AB/28/21/PL

19A, 19B, 19C, 21, 23, 25, 27 and 29 River Road Arundel BN18 9EY

Works to reinstate boundary walls, balconies & outbuilding.

Drawing Title	Proposed Detail Elevation 1
Scale	1:50 @ A3

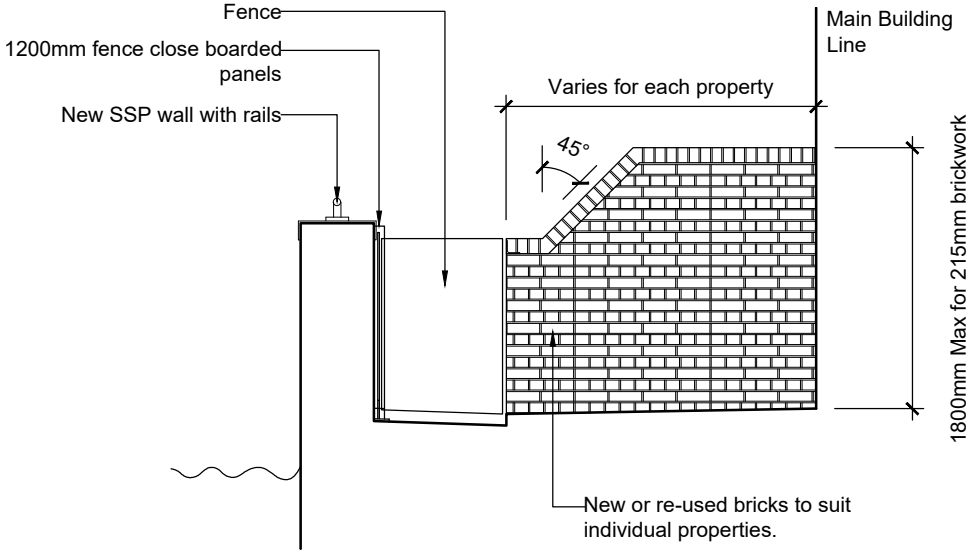
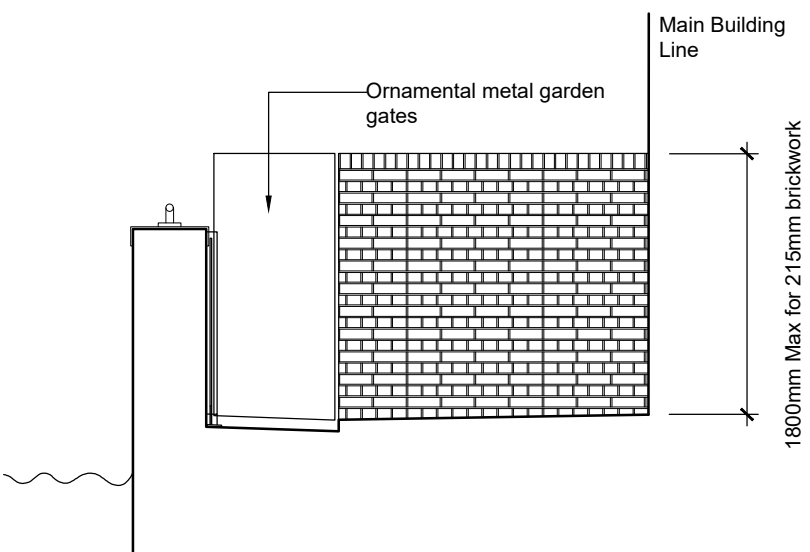
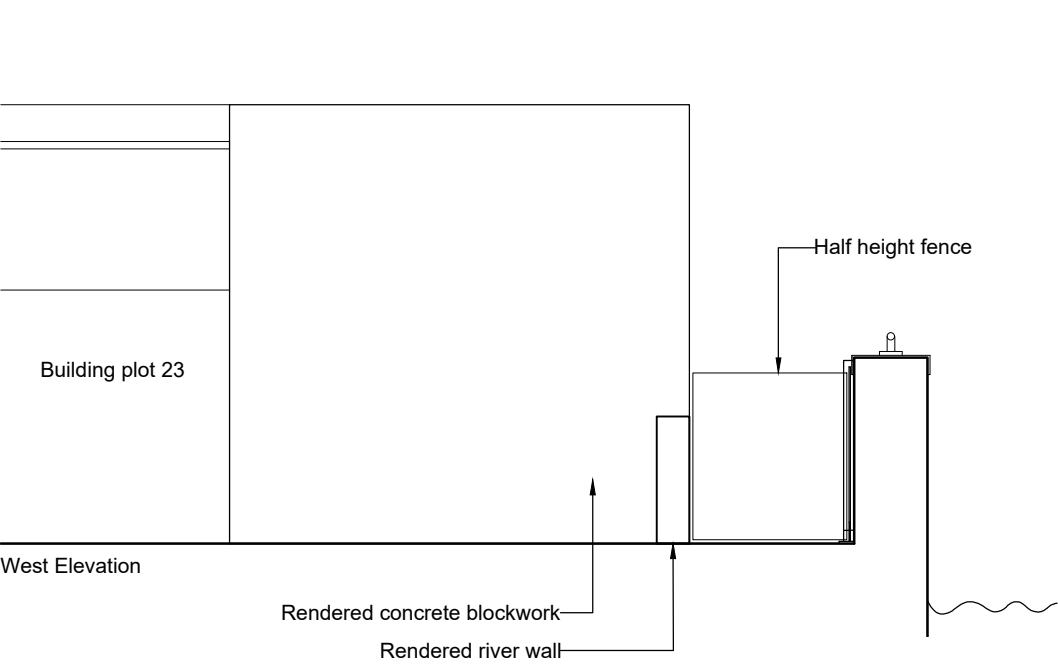
The application relates to works to reinstate various boundary walls, balconies and an outbuilding to various buildings along River Road. Whilst the reinstatement is understood and appears to be generally acceptable, it is unfortunate that the balconies proposed for number 19 A & B will not match that already granted consent at number 19C. However, it is positive to note that the detailed drawings indicate that an attractive brick bond will be used for all of the new walling.

The success of such a proposal will relate to the quality of the materials used and the workmanship. If minded to approve the application, you might like to request details of the bricks used in order to ensure that it reflects those already utilised in the buildings affected by this application.
